Hornsea Project One Deadline 1 Submission

1.1 This document is submitted for Deadline 1 in relation to the Hornsea Project Two Examination, jointly on behalf of Heron Wind Limited ("Heron"), Njord Wind Limited ("Njord") and Vi Aura Limited ("Vi Aura"). The three companies are collectively referred to as the "Project One Companies". The undertakers in relation to the Project Two Order (Optimus Wind Limited and Breesea Limited) are referred to in this Representation as the Applicants or the Project Two Companies.

Figure 1: Diagram showing the Project One substation infrastructure illustrating full utilisation of the Order Limits for the substation.

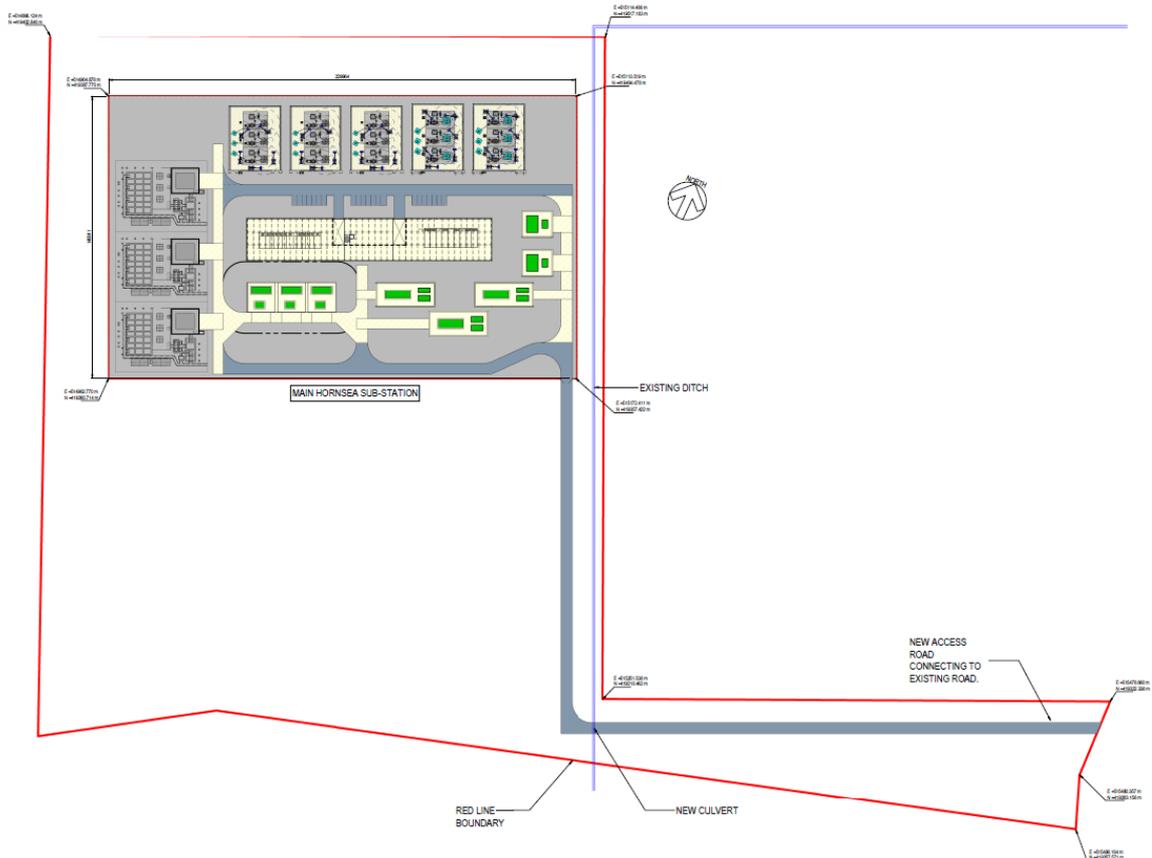
- 8.1 There are a number of locations identified within the Project Two Work Plans where there is a complete overlap and, as a consequence, possession proposed for the usage of temporary working areas. This is particularly clear at the onshore substation site.

- 8.2 There is an area of proposed permanent acquisition of part of the Project One substation area. This should either be removed, or made subject to Protective Provisions which mean that land/rights can only be acquired with Project One's consent.

- 8.3 **Proposed solution:** The Project One Companies require the removal of Plots 503, 505, 507 and the northern part of Plot 506 (shown separately on Overlap Plan 1) from the Development Consent Order and the Book of Reference.

- 8.4 The Project One Companies require suitable Protective Provisions to be included within the Development Consent Order in relation to the other Plots where there is overlap between the powers sought for Project One and Project Two and/or for the relevant matters to be dealt with under a confidential cooperation agreement between the two projects.
